Recommendation Report for Planning Permission for Works or Extension to a Dwelling

REF NO: AW/216/15/HH

LOCATION: 25 St Richards Drive
Bognor Regis

PROPOSAL: New extension forming kitchen, dining room and bedroom to the first floor. Roof extension including bedroom 5 and en-suite - Resubmission of AW/216/15/HH

Drawing 2 / 6

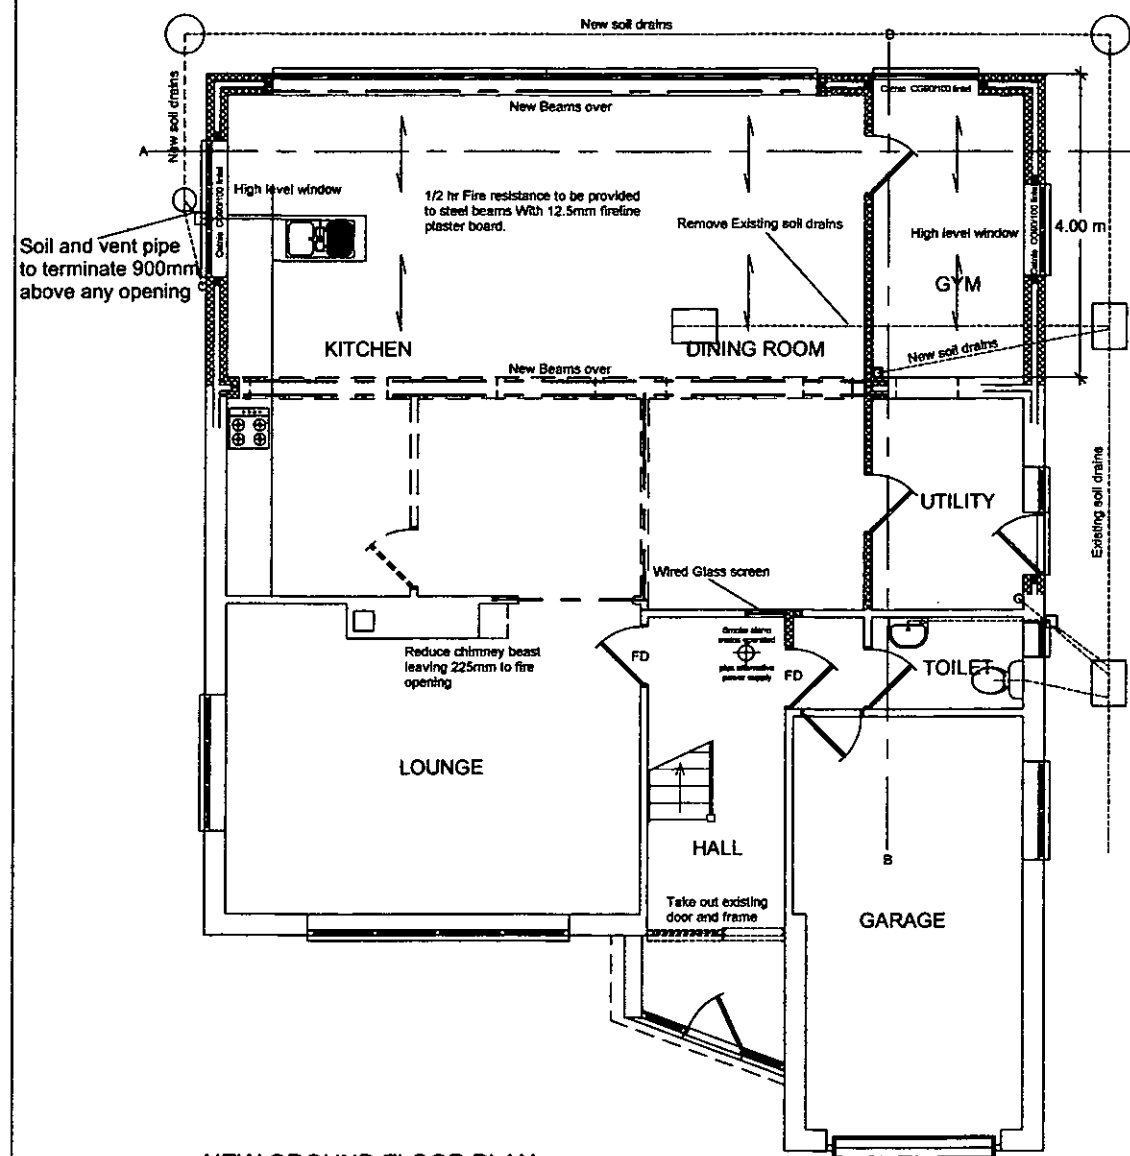
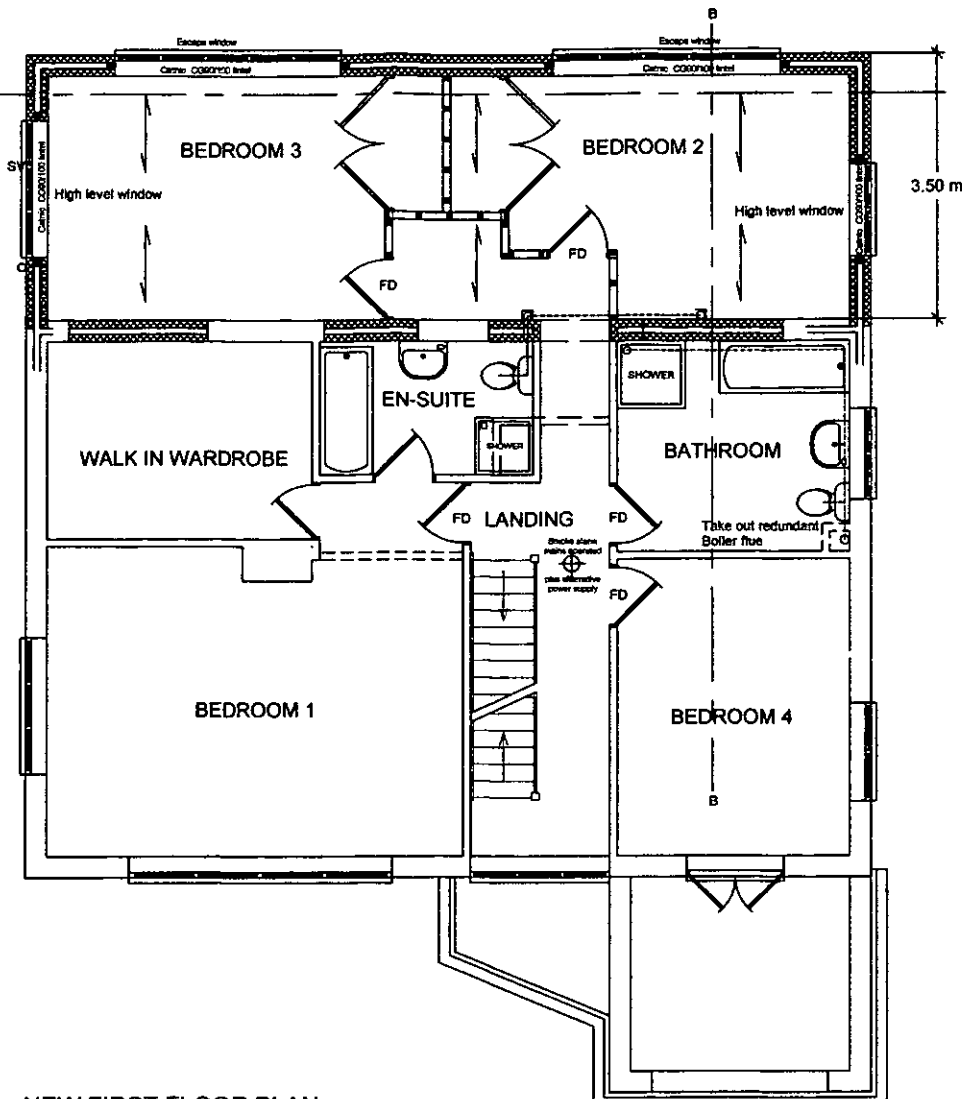
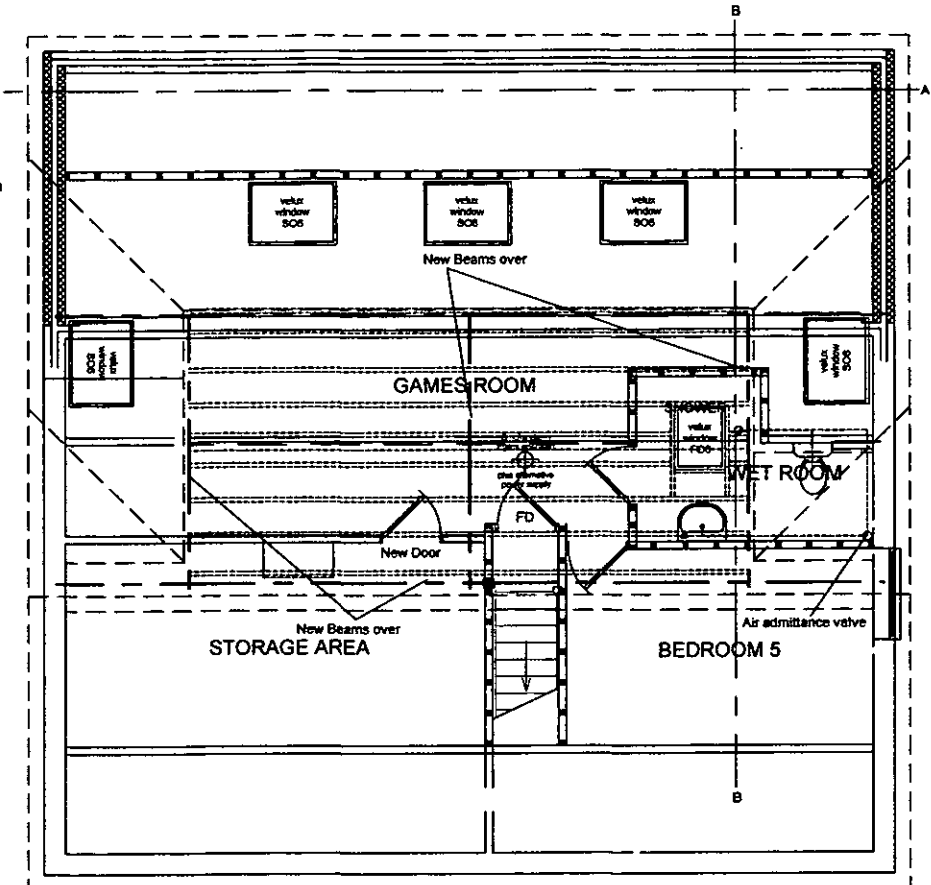
The extension moves the rear openings outwards between 3.5m at first floor, it is difficult to conclude that this would result in increased overlooking or privacy loss, since there are already rear facing windows and those proposed do not result in an appreciable increase in glazed area.

Drawing 4 / 6

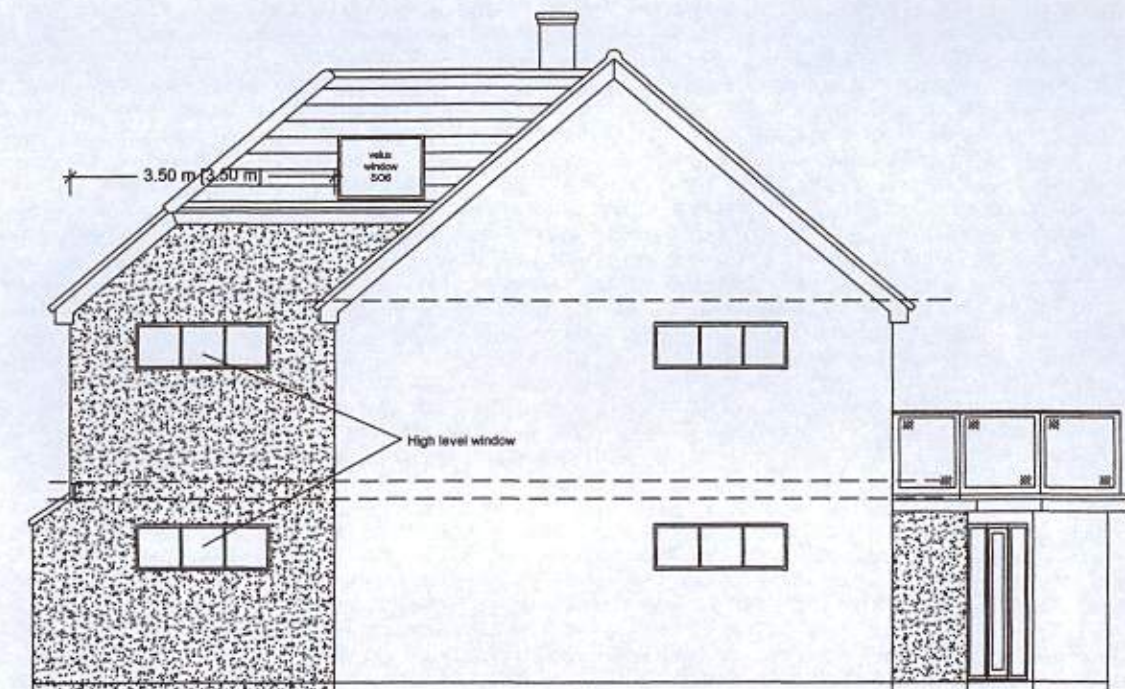
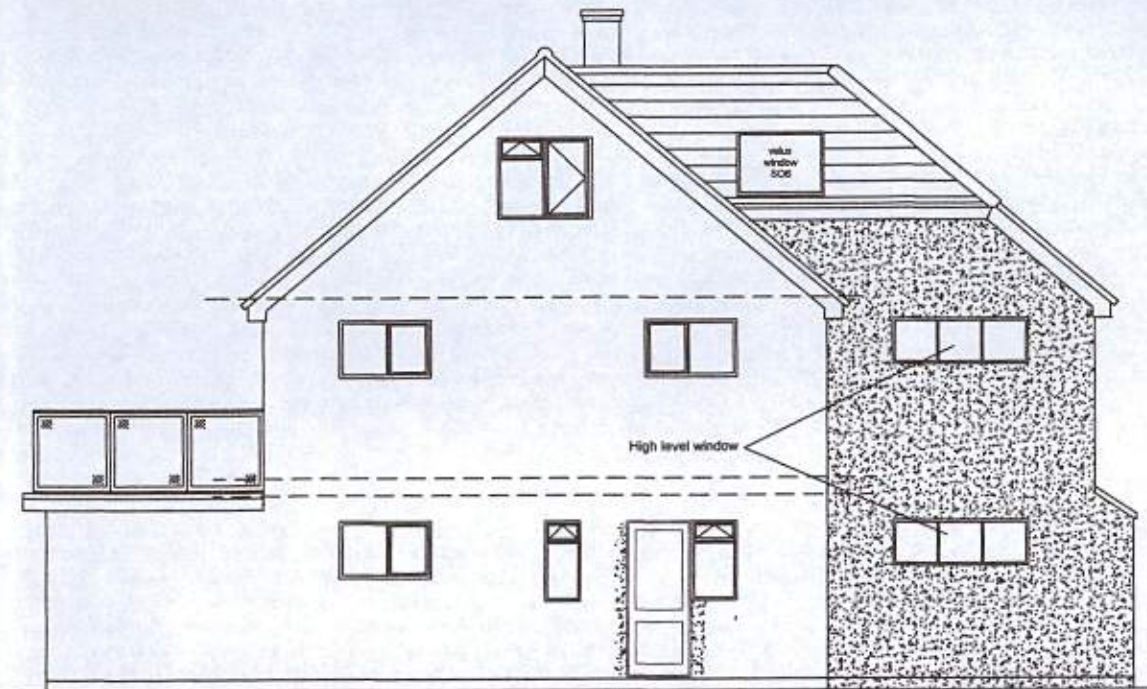
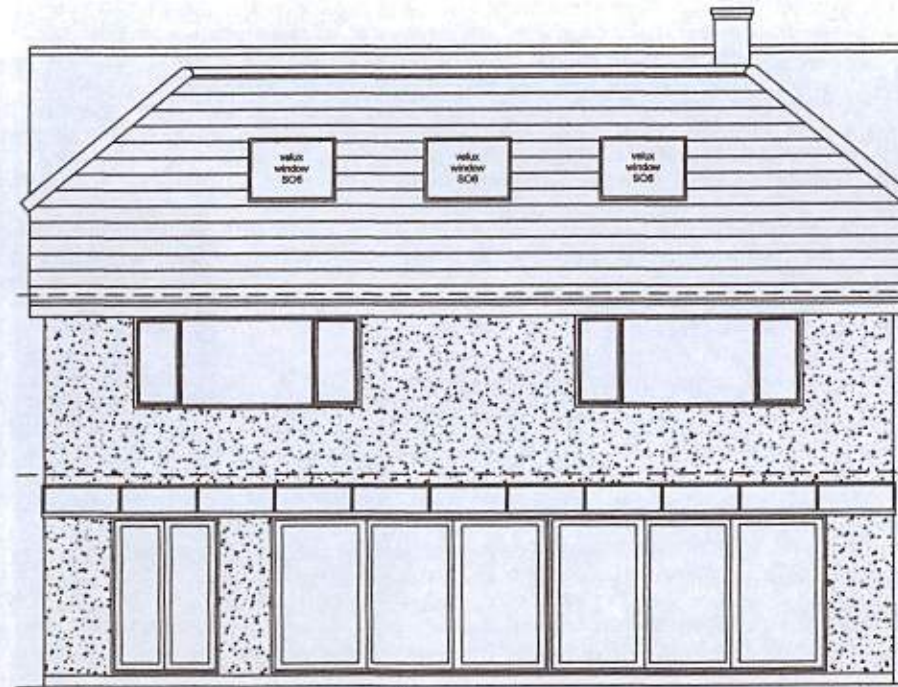
The design will result in an increase in the two-storey gable facing adjoining dwellings by 4m from 7.4m to 11.4m. There will be an increase in impact on outlook from adjoining dwellings, although this impact will not be significant for no.26 given that it has ground floor windows screened by the panel fence. No.24 has windows facing the site, although these are screened by a wooden panel fence and in no.24 has its garage adjacent to the area of the extension. Adjoining dwellings are set away from the boundary and this further mitigates impact. Whilst the gable will be deep, it is not considered to be so great in depth, taken with the screening, that there would be harm to visual amenity such that permission should be refused.

Potential overlooking or privacy loss from side windows or side roof lights can be prevented by imposing a condition requiring these windows and roof lights to be obscure glazed and non-opening in perpetuity.

- 4 The windows in the east and west elevations and the roof lights in the east and west roof planes of the extension hereby permitted shall at all times be glazed with obscured glass.
